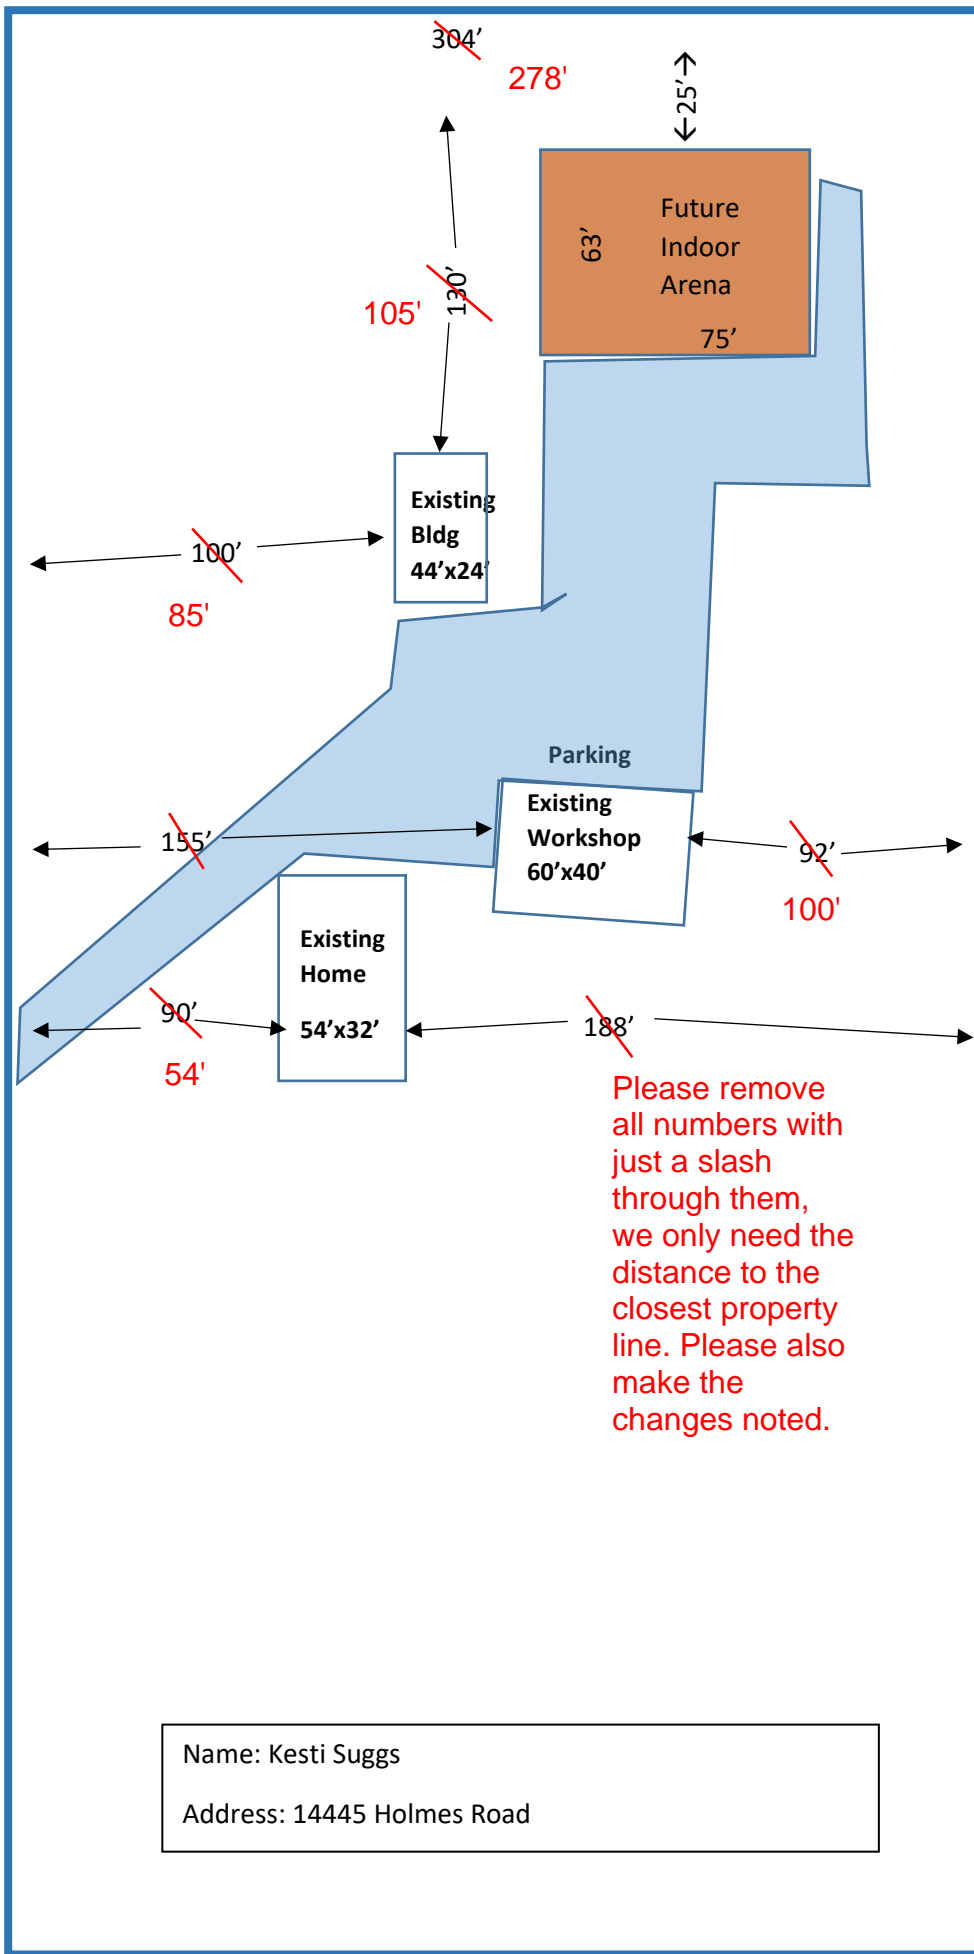
this is not ROW, please call out as private access to adjacent parcel or remove altogether.

Needs to be setback at least 25 feet from side and rear yard property lines.

Must be at least 35 feet away from a residential structure

Please call out existing road (Holmes Road) here.

Mark what the roads are.

Mark setbacks of all structures to nearest property line.

Please label the sheet with your name and address.

Please show all distances from each existing and proposed structure to the property lines.

Please call out your property lines and depict as accurately as possible (for example, it appears as if your lot is a perfect rectangle, please show that here, also, I believe your north line is 304' minus 30' for the ROW of Holmes Road. Please show that line as 274'.

Please add north arrow
